Rezoning Transportation Analysis
Petition Number: Insert Zoning Petition #2021-161
General Location Identifier: 22902119

Revision Log:

Date	Description
08-20-2021	First Review (WB)
09-17-2021	Second Review (WB)

Sheet No:
RZ-1

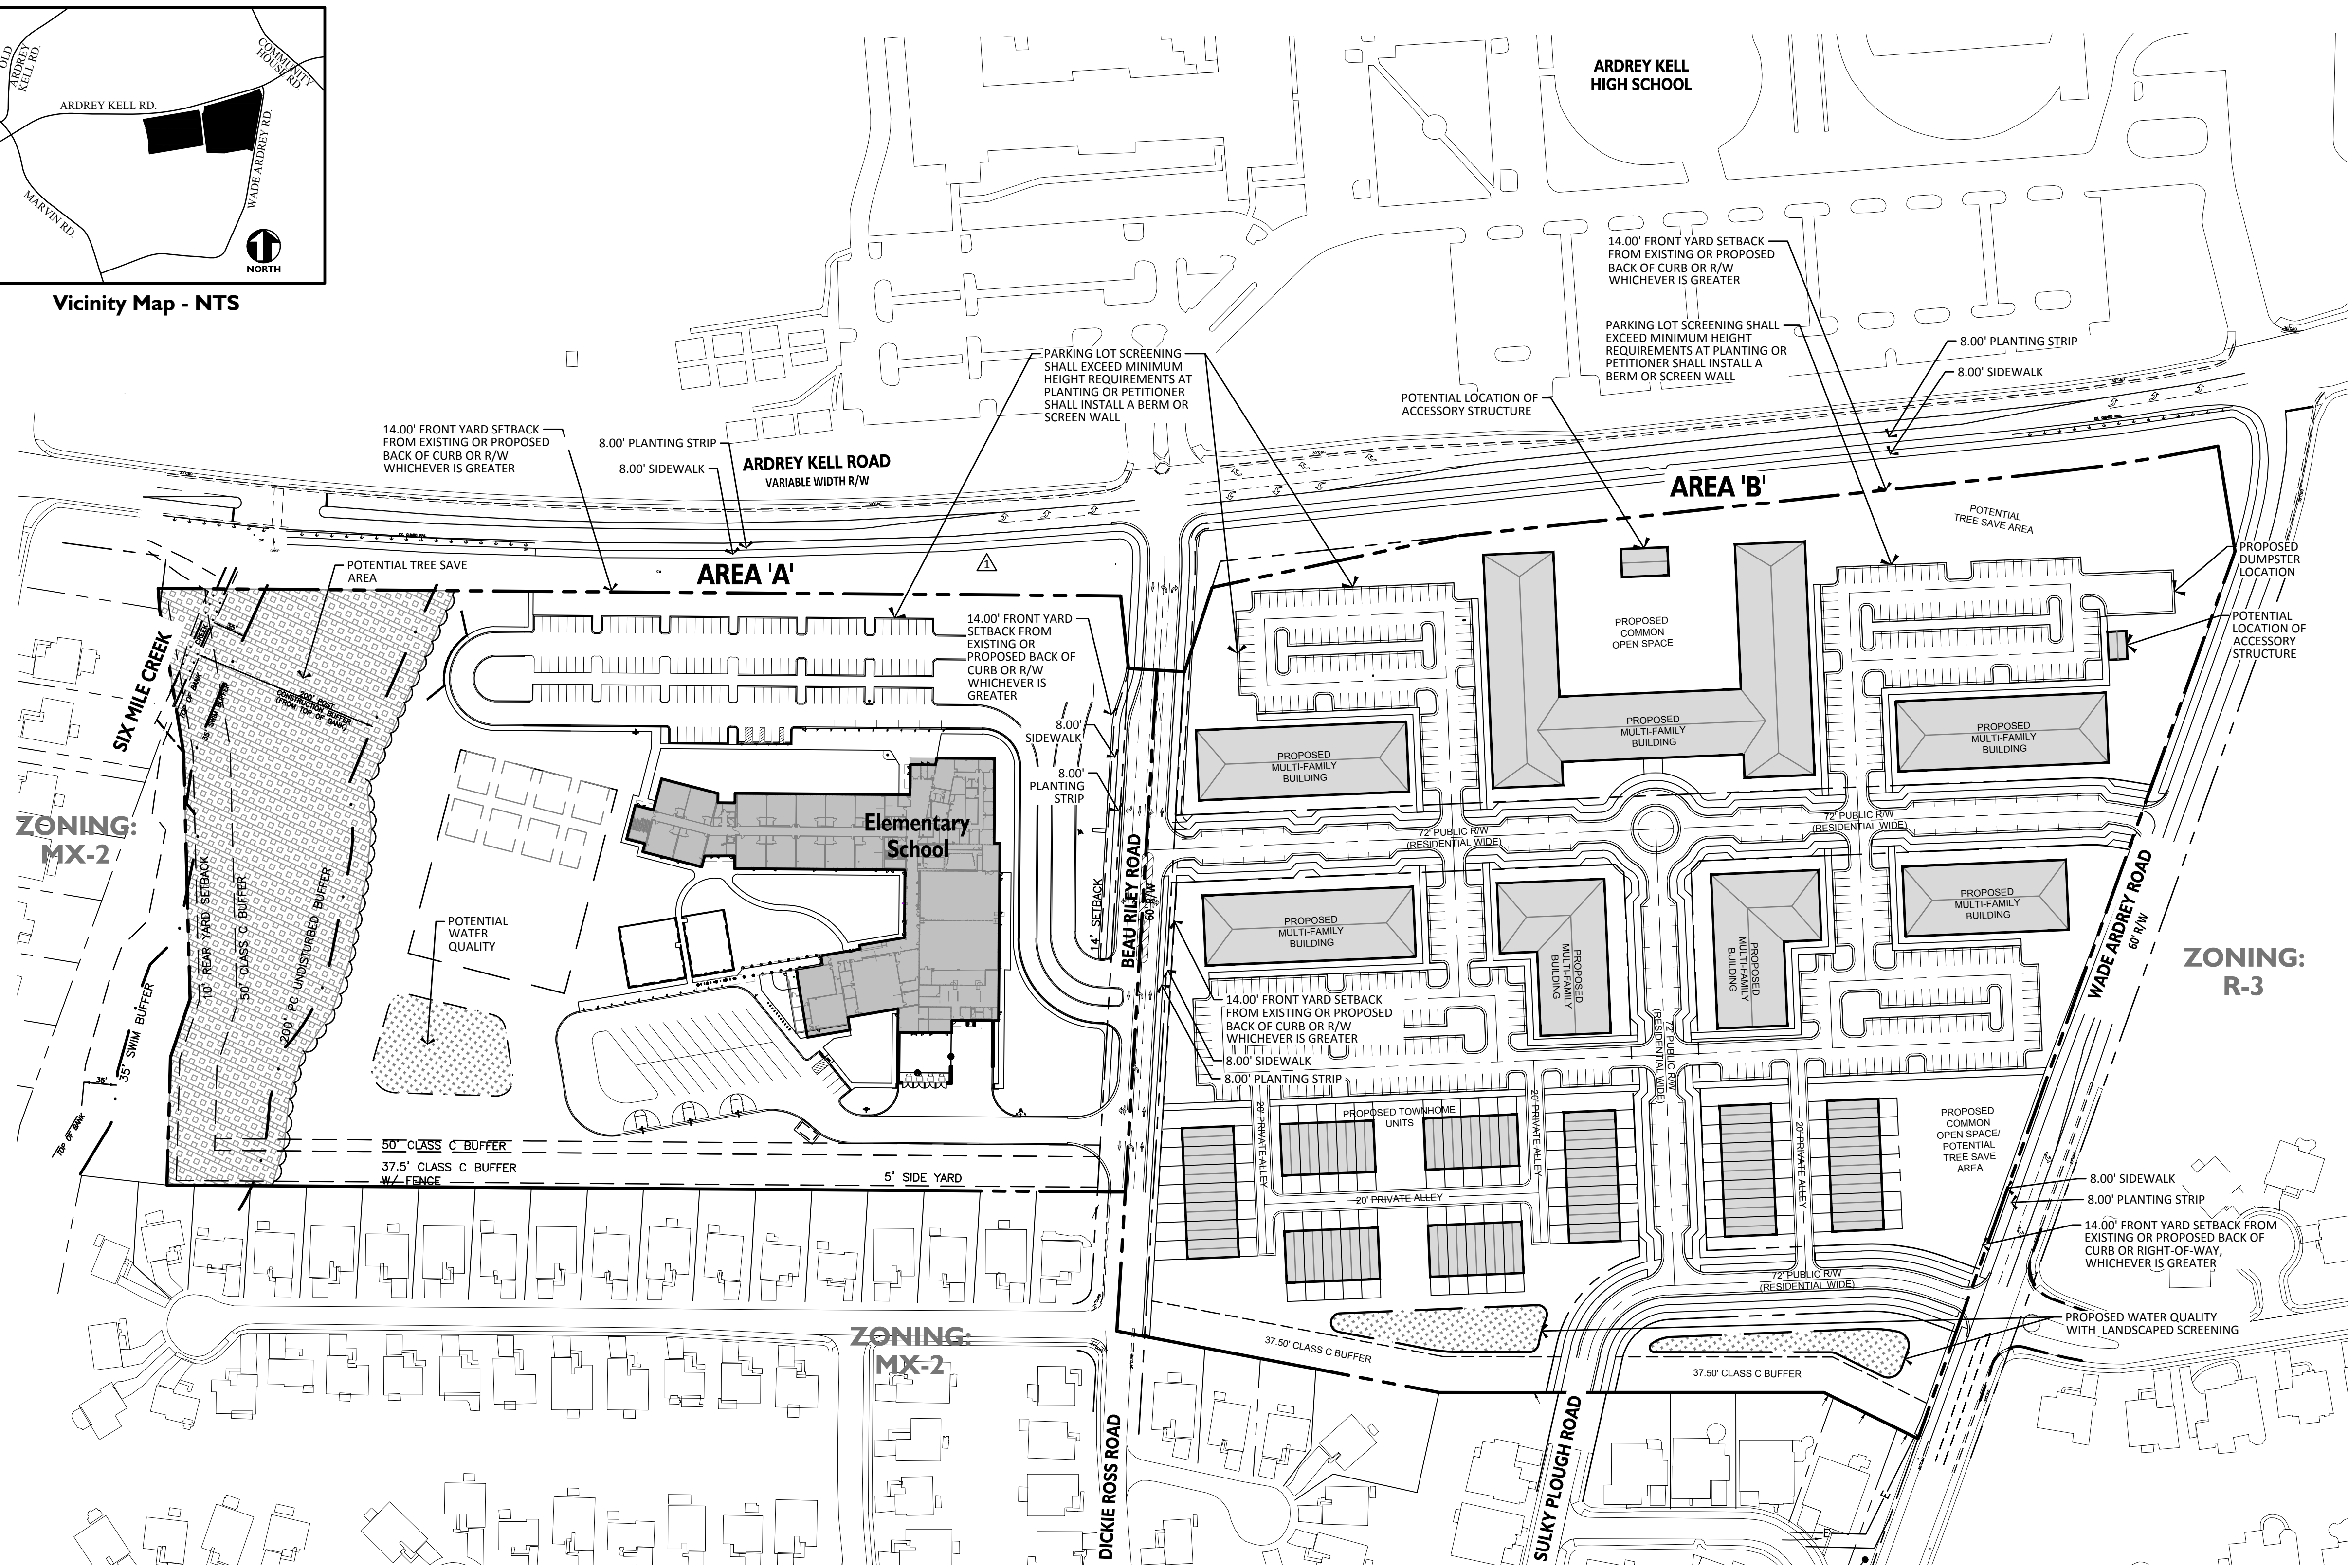
- a. ~~**Ardrey Kell Road:** The existing curb and gutter is in its future location. No curb relocation required.~~
- b. ~~**Beau Riley Road:** The existing curb and gutter is in its future location. No curb relocation required.~~

~~Label and dimension the curb and gutter from the centerline for each road on the site plan.~~

- ~~3. The proposed dwelling units exceeds 12 per acre. Per Chapter 20 Subdivision ordinance, site plan and conditional note(s) revisions are needed to commit to construct an 8-foot planting strip, and 8-foot sidewalk along Beau Riley Road. The wider sidewalk also meets the Charlotte WALKS Policy.~~

- ~~4. Site plan and conditional note(s) revisions are needed to commit to installing a 12' multi-use path with an 8' planting strip, along the site's Ardrey Kell Road Frontage to meet the Charlotte BIKES and Charlotte WALKS Policies.~~

- 5. ~~Revise site plan and conditional note(s) to identify, depict, label, dimension, and itemize all proposed transportation-related infrastructure improvements. The conditional notes should include commitments to fully construct and fund all TIS-recommended and ordinance-required transportation improvements with applicable phasing and funding sources identified.~~

- ~~6. Add conditional note that all public transportation improvements will be constructed and funded by the residential development before the residential site's first building certificate of occupancy is issued.~~
